ENG-SF20015-R1-CDs.pdf Markup Summary

BYNUM DRIVE
STA 0+00.00 TO STA 9+24.77

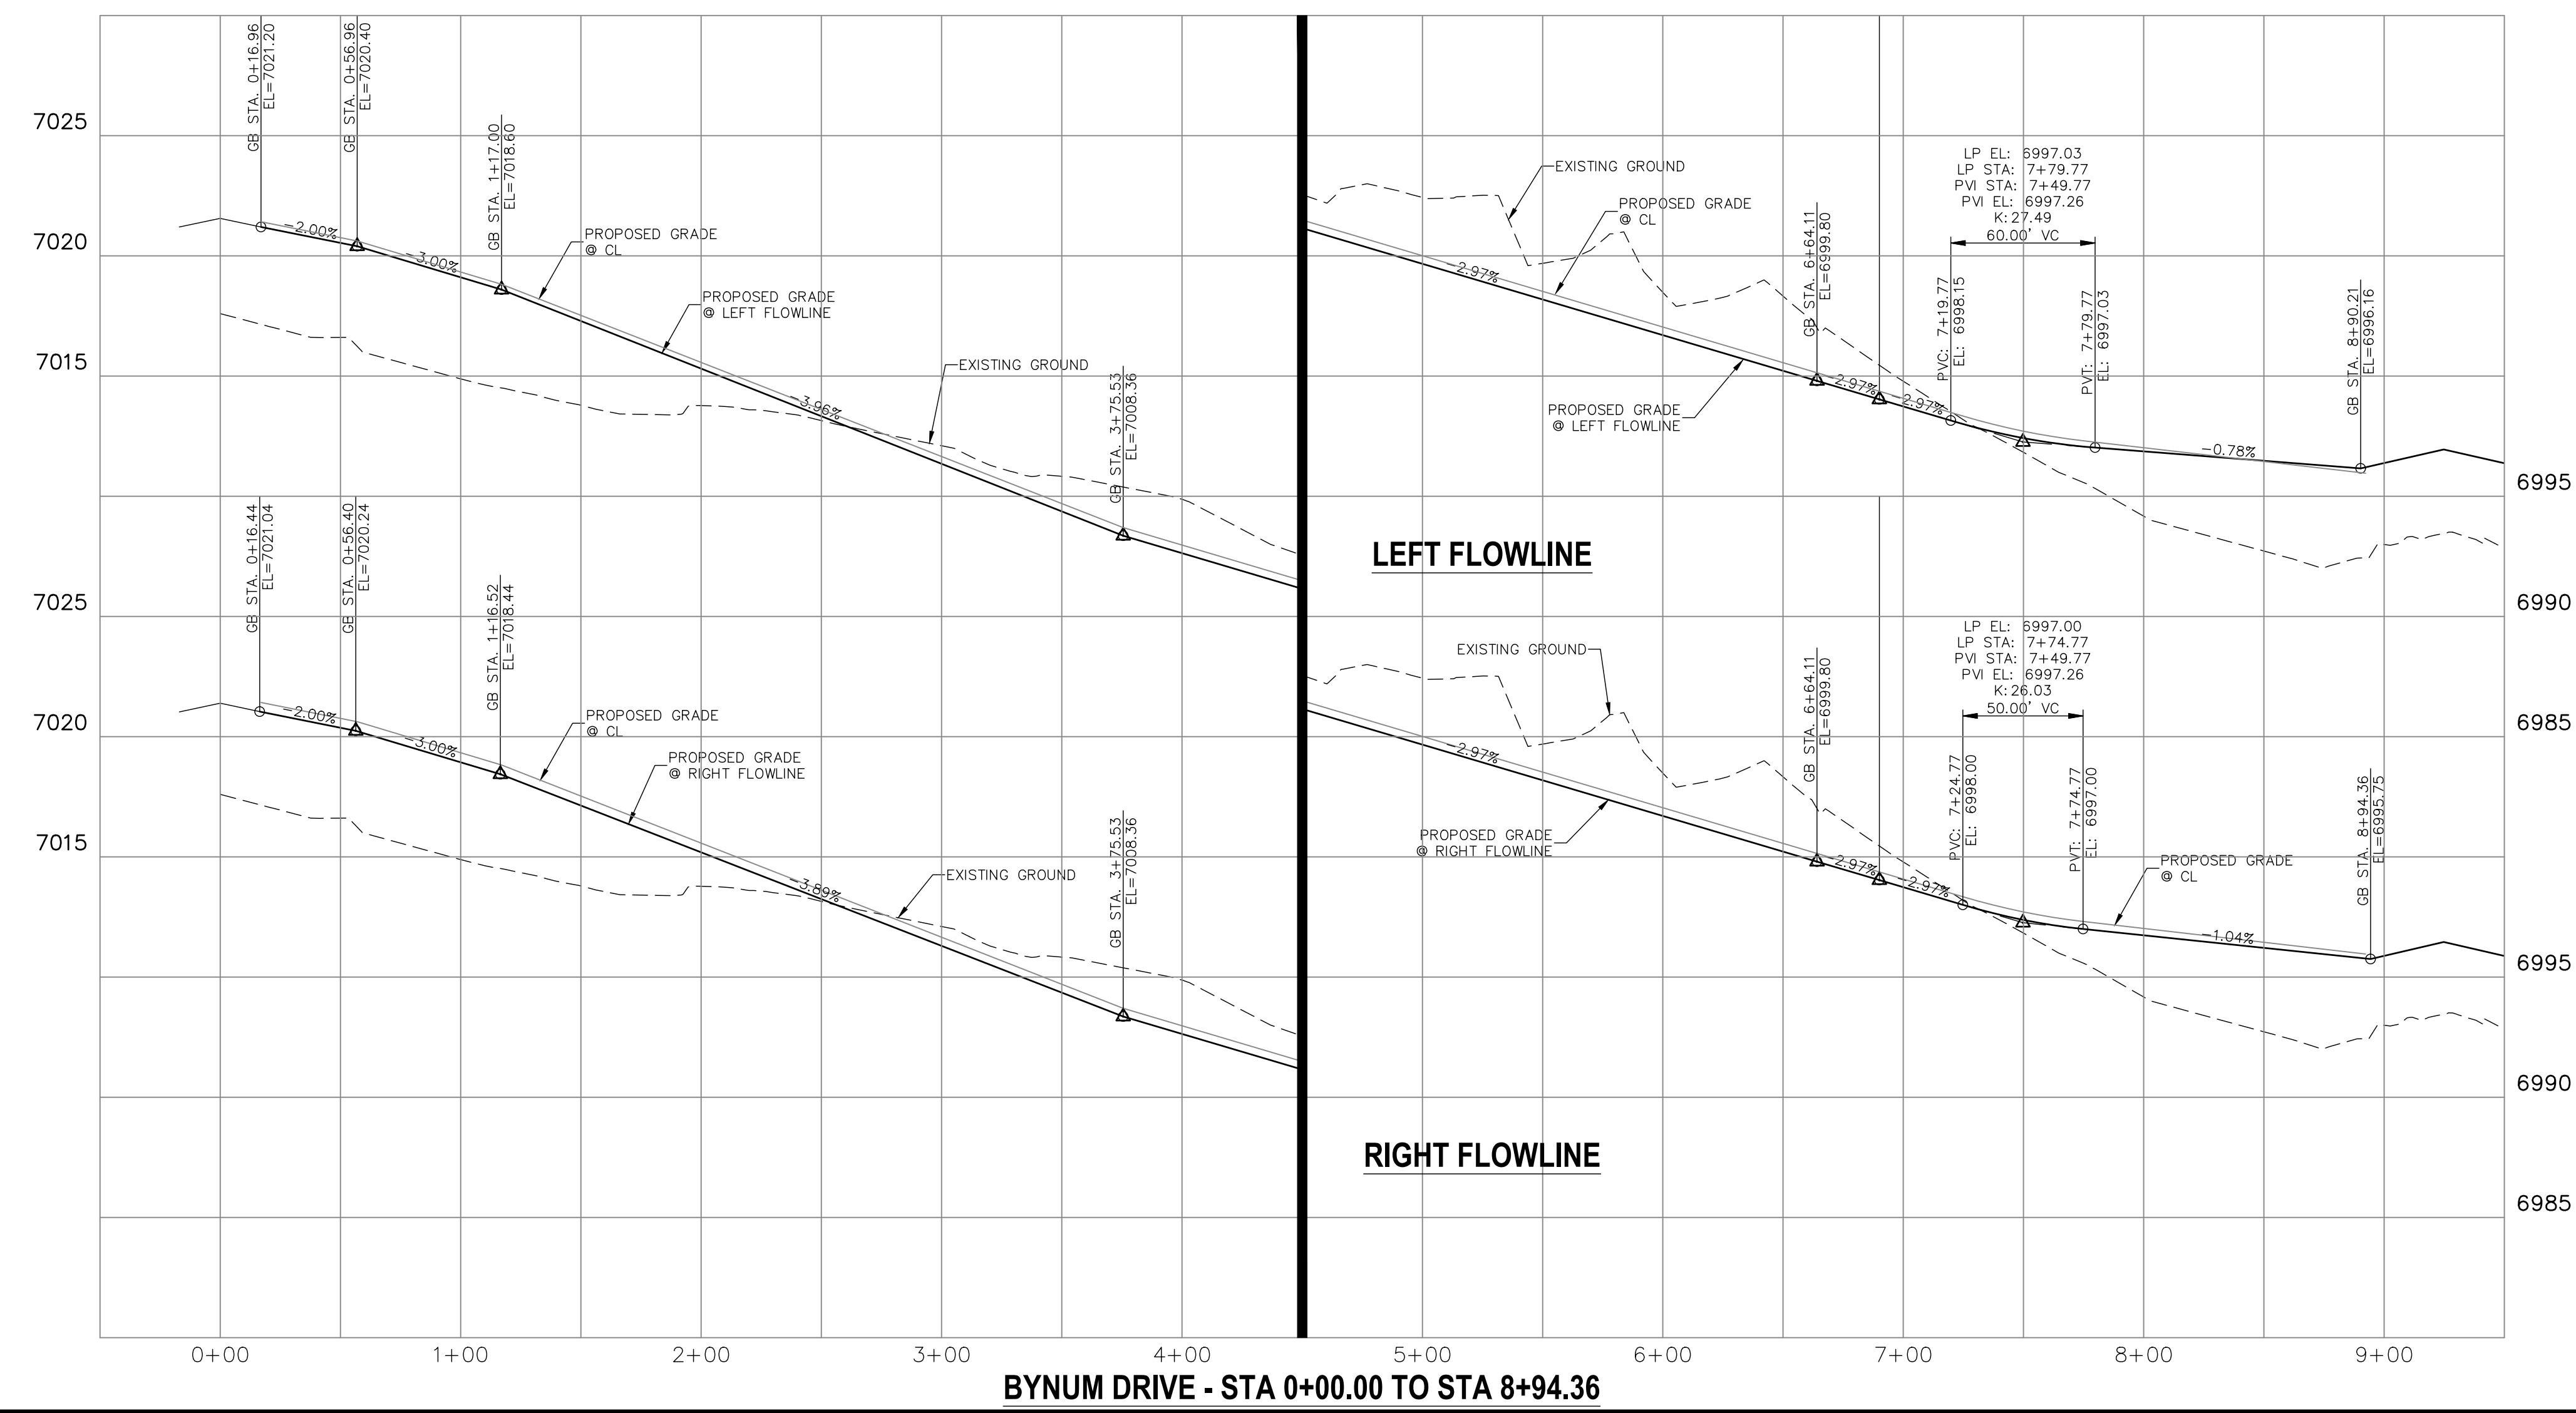
Provide Bynum Dr. typical section (36' paved) per Preliminary Plan.

Label design and posted speed.

STRM_19 PROFILE STA 0+00.00 TO 13+29.82 PRIVATE (SRMD)

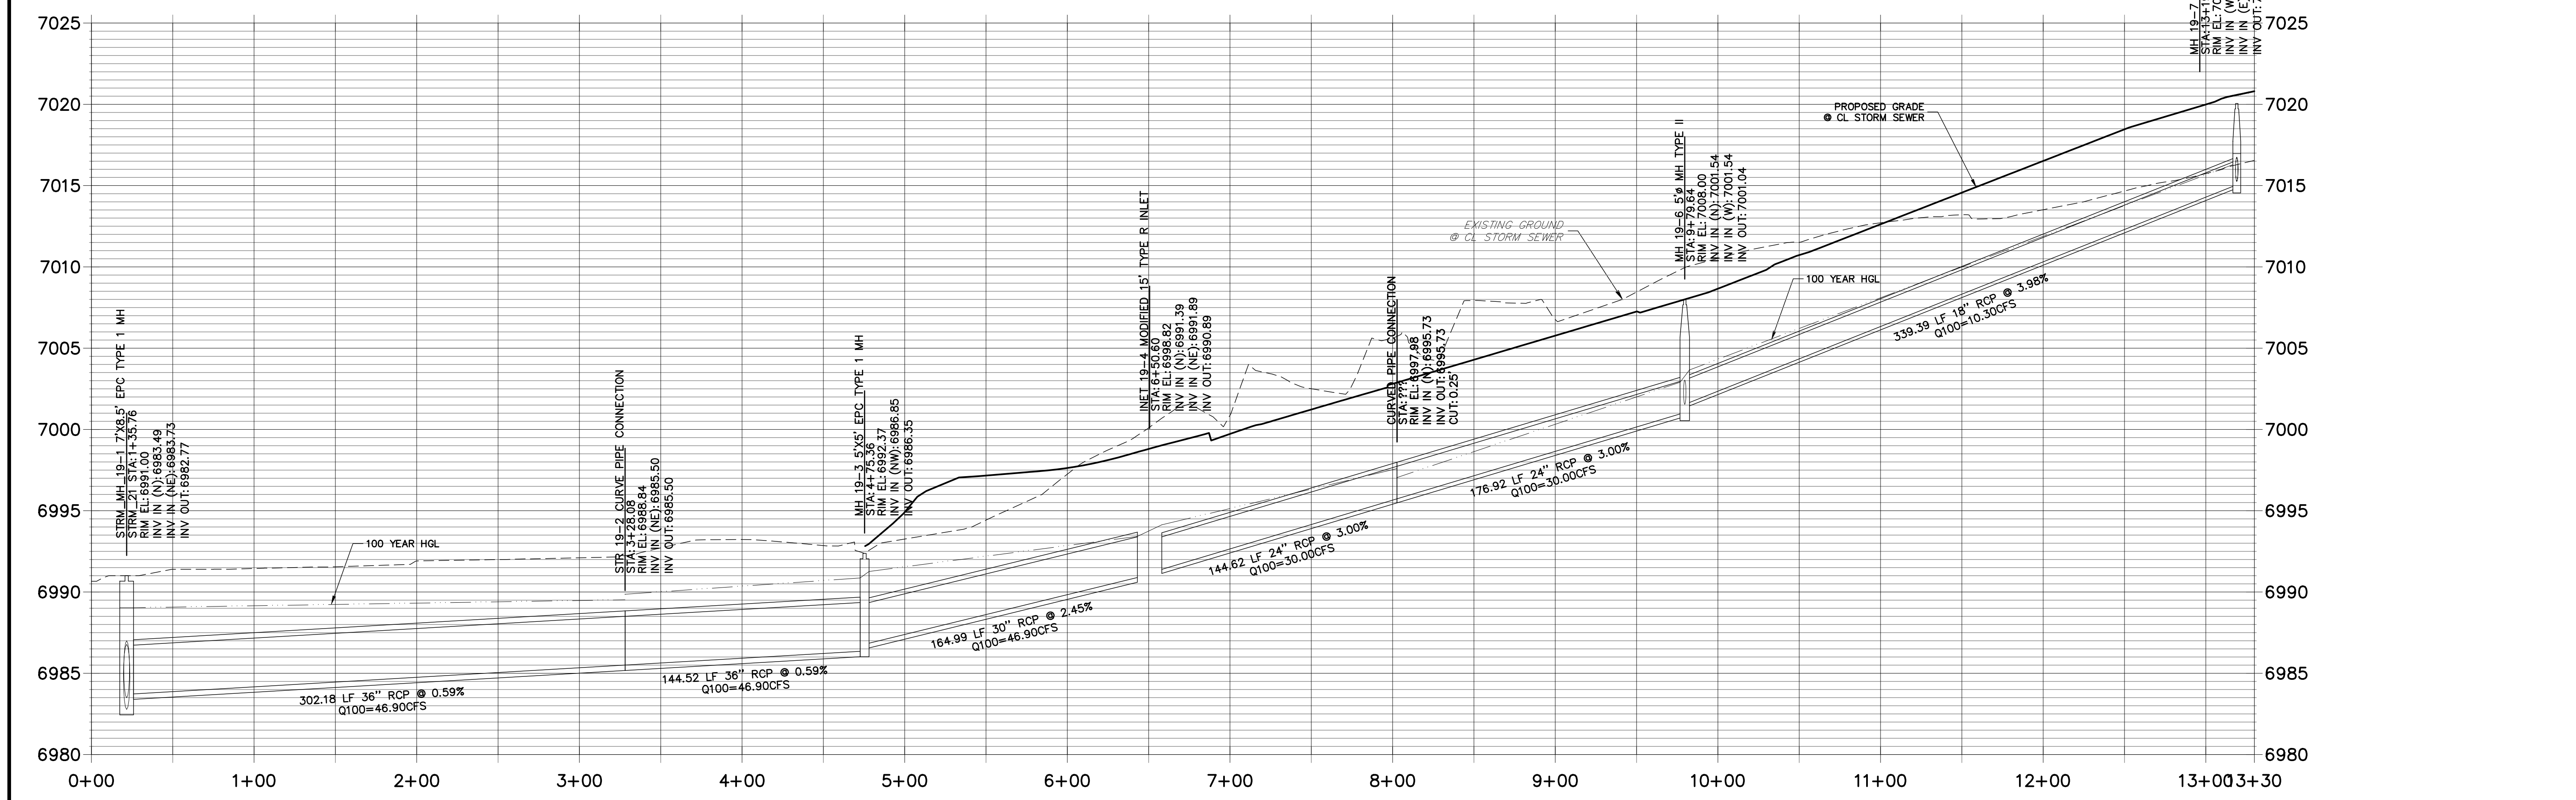
HGL outside of pipe requires watertight joints - add note specifying this where applicable (all sheets).
